**Relevant Representation of Suffolk
County Council in respect of the
proposals for the Sizewell C Nuclear
Power Station under section 56 of
the Planning Act 2008**

28 September 2020

SECTION B - B
SCALE 1:200

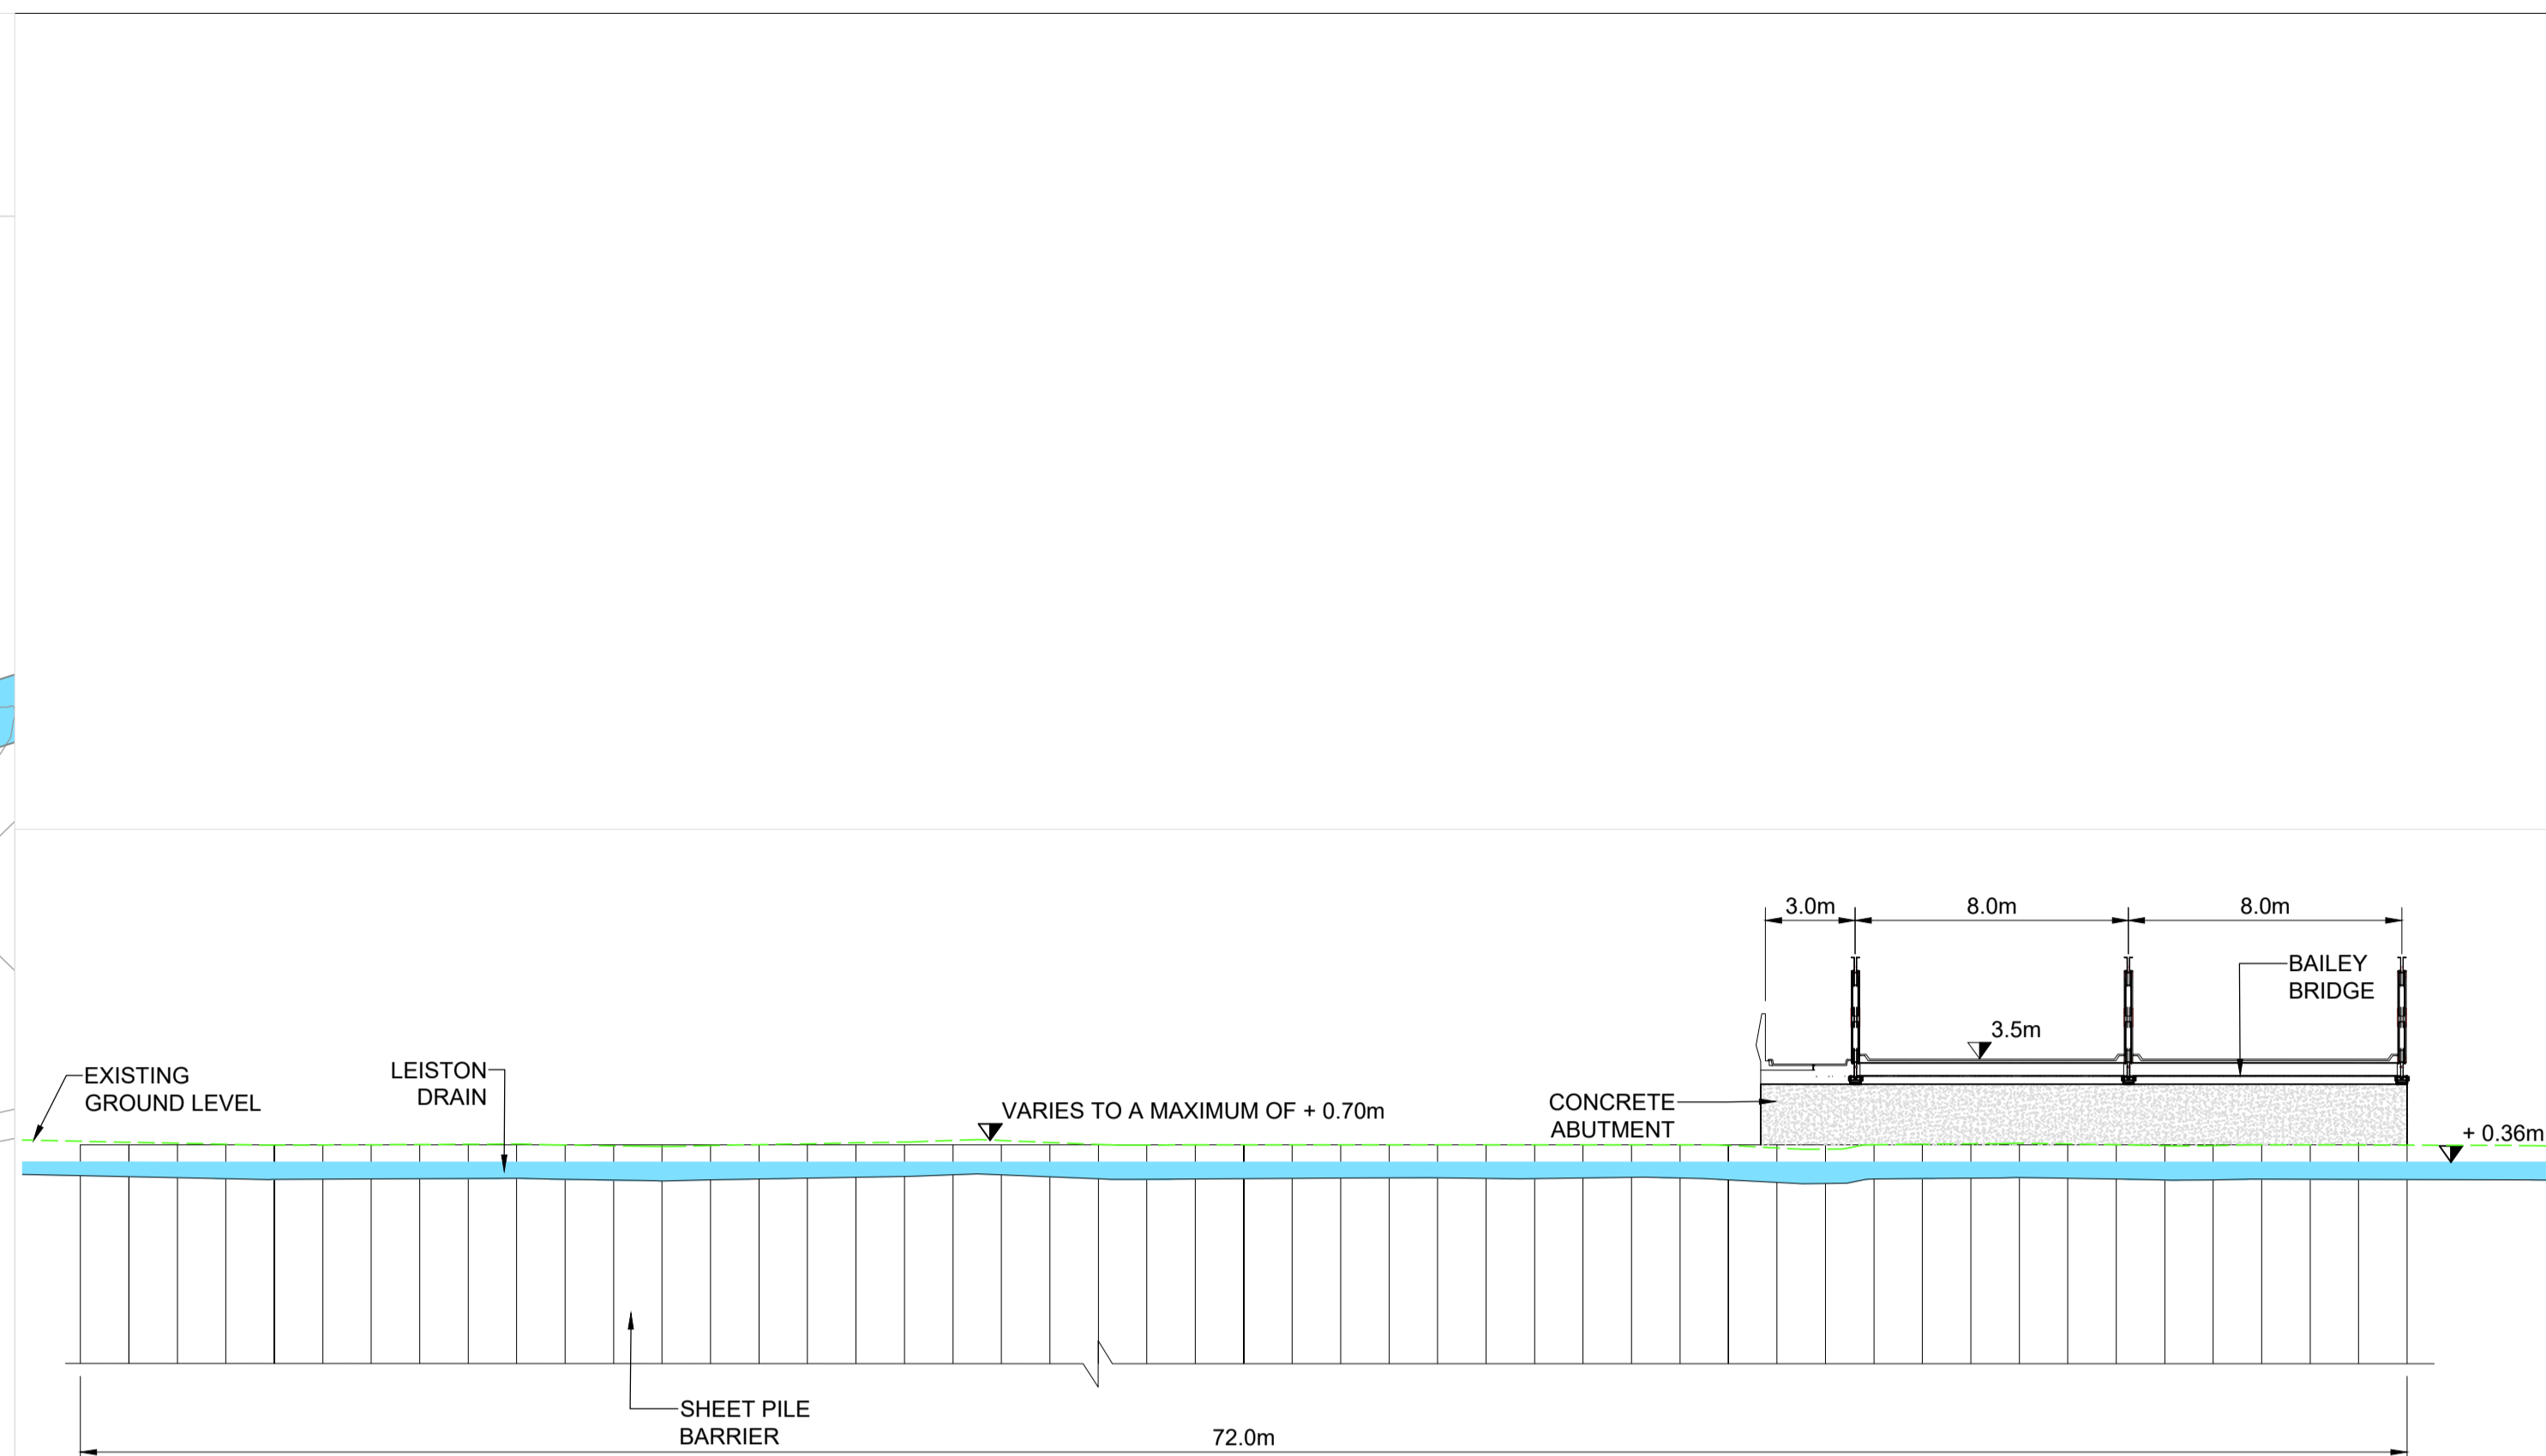
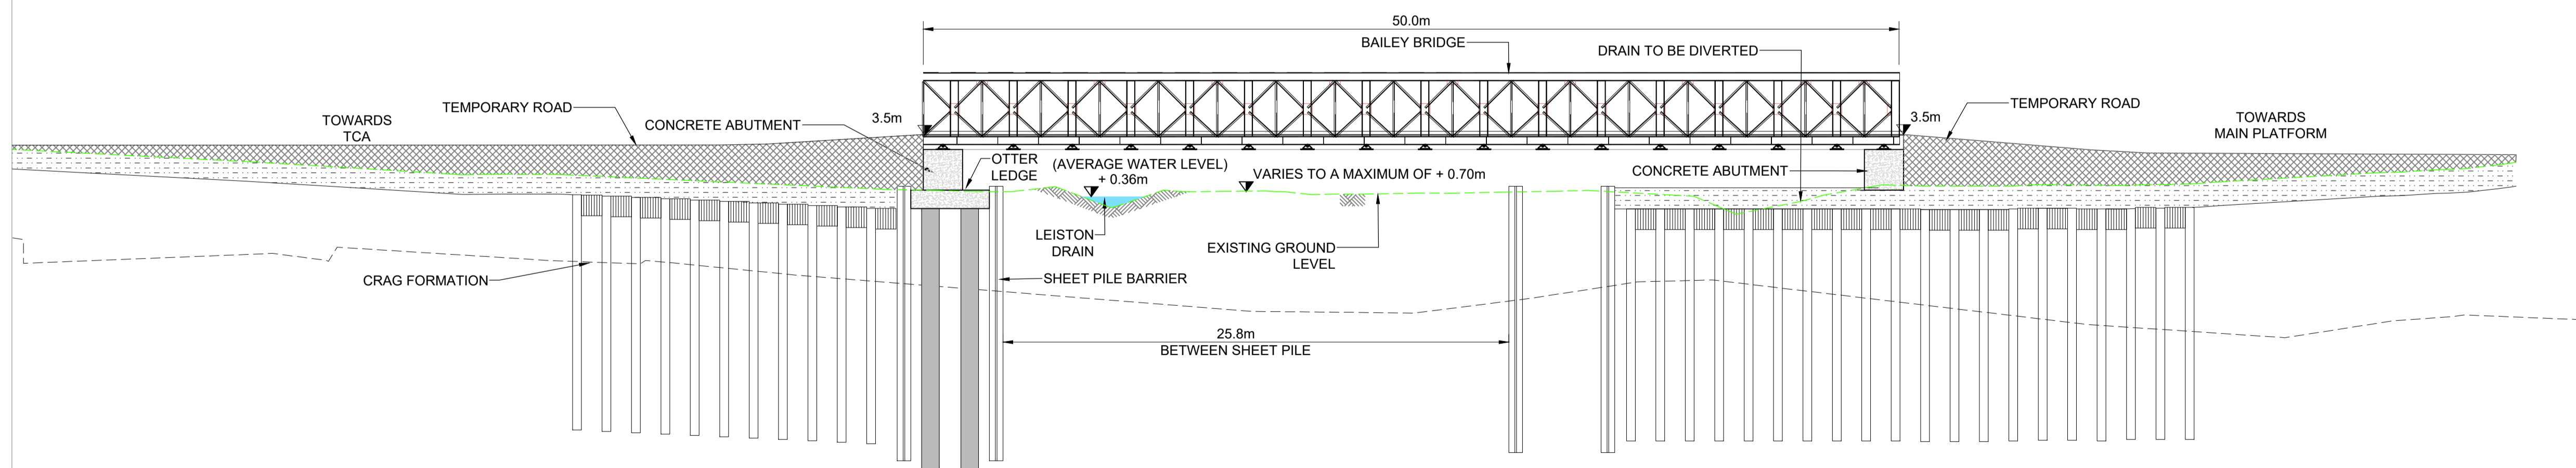
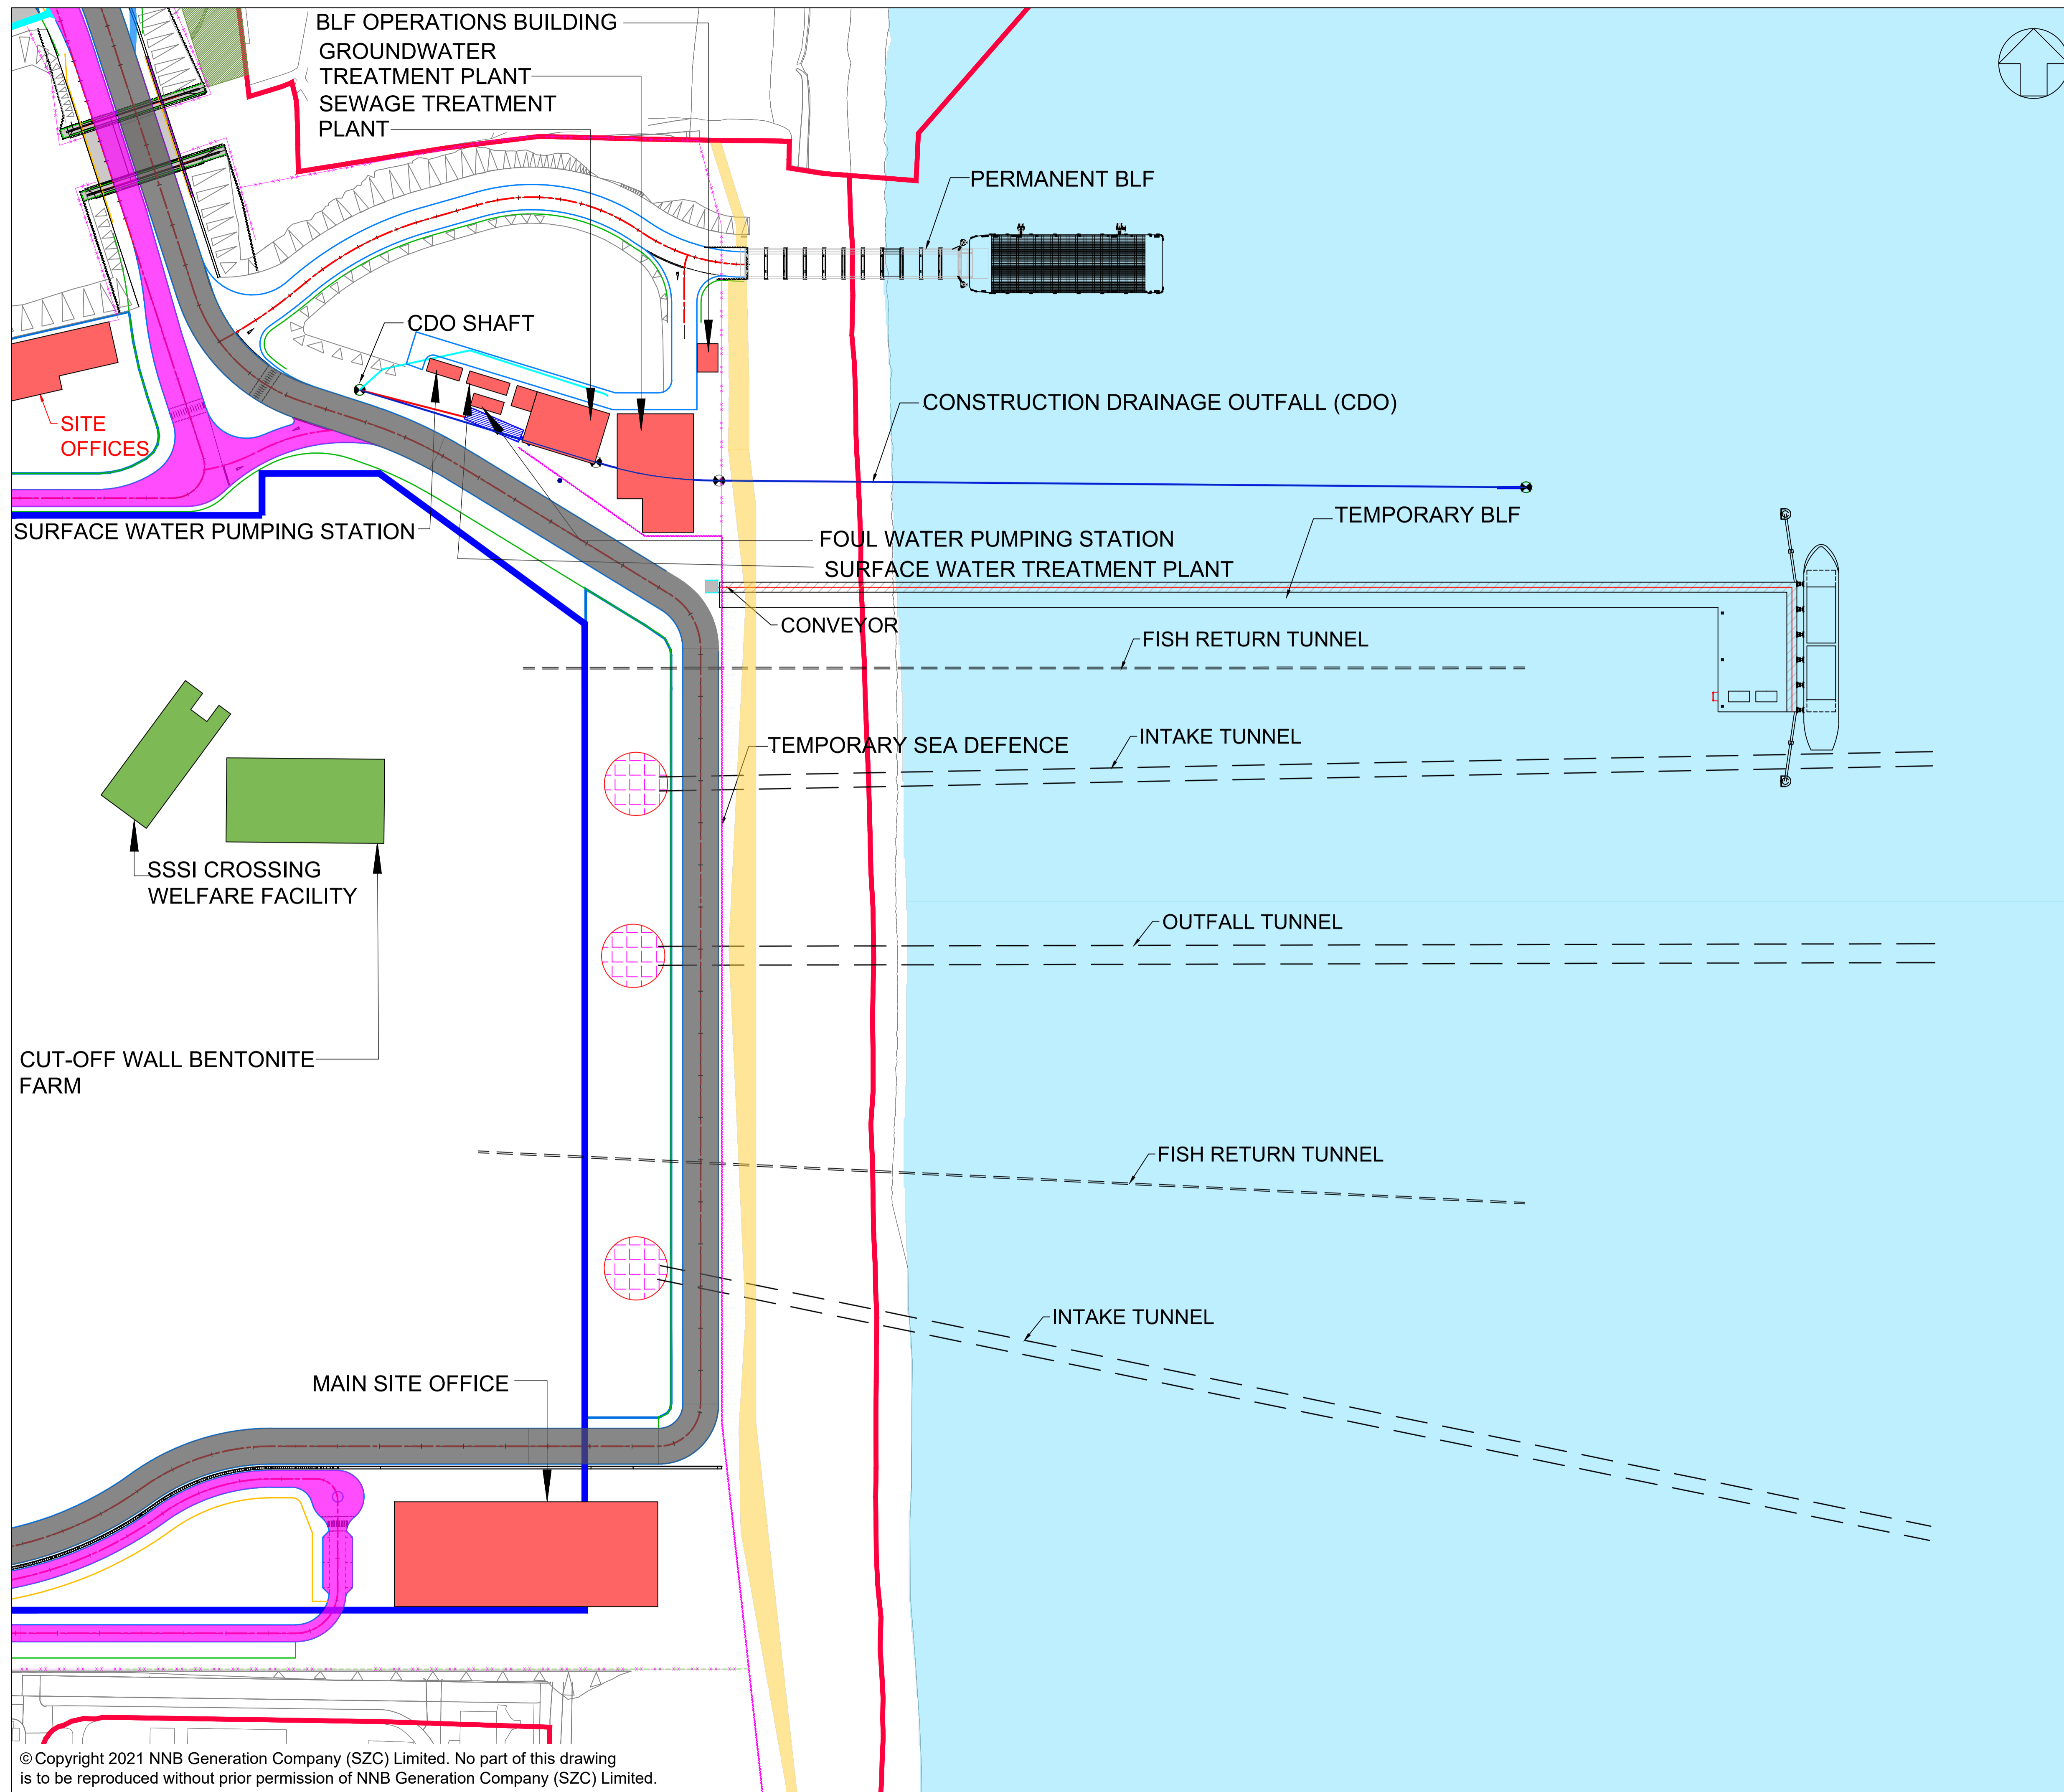
- vii) Replacing the proposed causeway to cross the Sizewell Marshes Site of Special Scientific Interest (SSSI) with a three-span bridge design, to reduce its ecological impact;
